ARUN
DISTRICT COUNCIL

From: Jonathan Best <Jonathan.Best@arun.gov.uk>
Sent: 23 January 2026 14:06
To: Planning.Responses <Planning.Responses@arun.gov.uk>
Cc: Jessica Riches <Jessica.Riches@arun.gov.uk>
Subject: P/175/25/DOC

Appendix 1

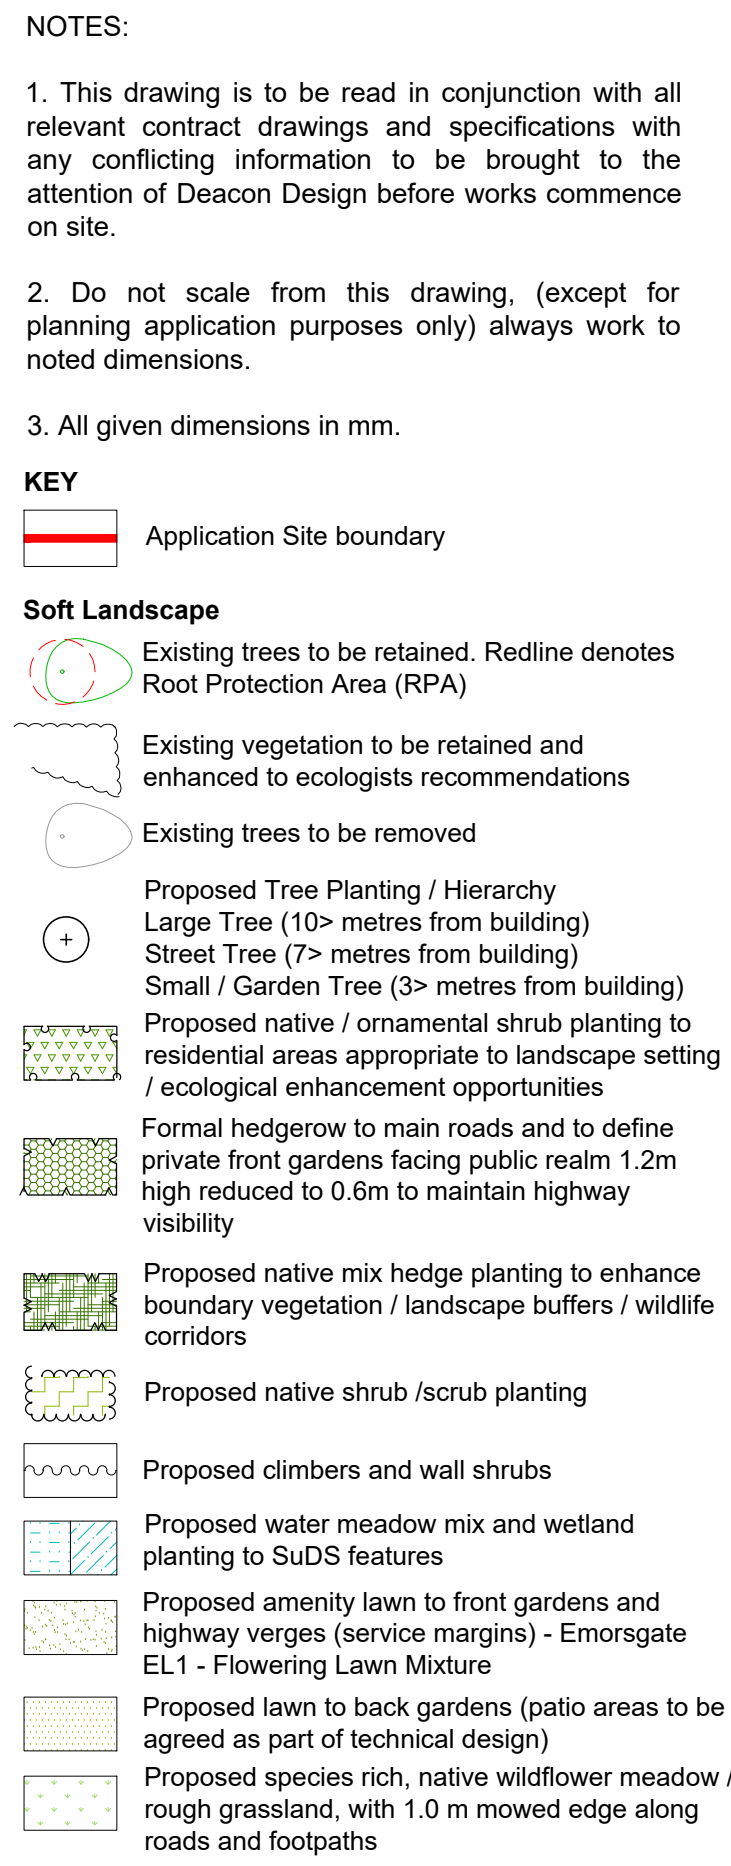
I am a little concerned about the timing of the planting as there appears to be a gap of at least a month between the clearance and land preparation and the planting. I advise that the hedge should be planted at the earliest available time between January and March. The later the planting

the greater the risk of failure due to lack of bedding in time, reduced growing season and possible dry spring conditions.

There is a risk that with this proposed timetable the hedge may not be in place before the construction works begin.

Before I recommend discharge clarification on the timings for the planting in relation to the commencement of works is required.
